# CITY OF ALBUQUERQUE

November 6, 2020

**Re: RGPU Marble  
1201 San Pedro Dr. NE  
30-Day Temporary Certificate of Occupancy  
Transportation Development Final Inspection  
Engineer's/Architect's Stamp dated 5-22-20 (J18D008)  
Certification dated 10-30-20**

A1 SITE PLAN

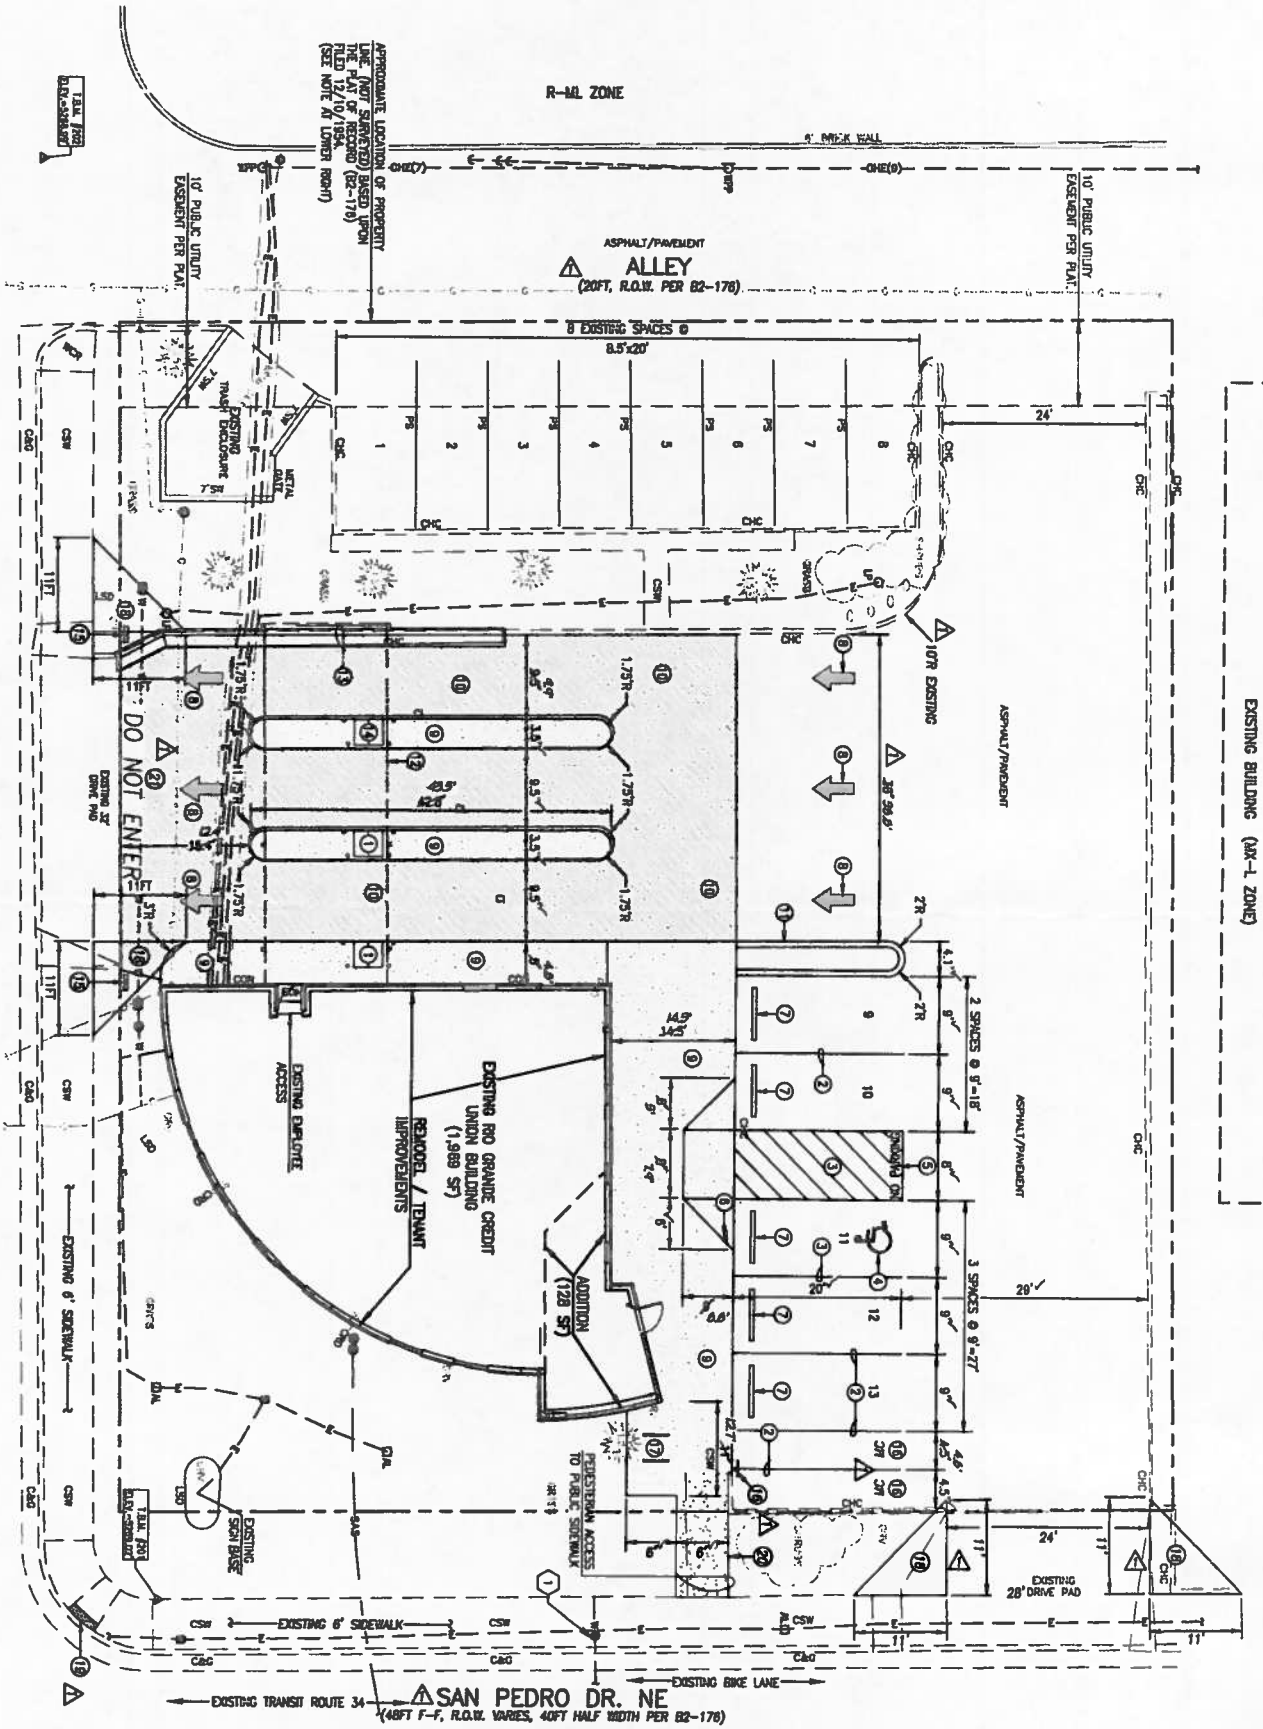
- Please correct cracked broken sidewalk.
- Please remove construction debris and materials from site.
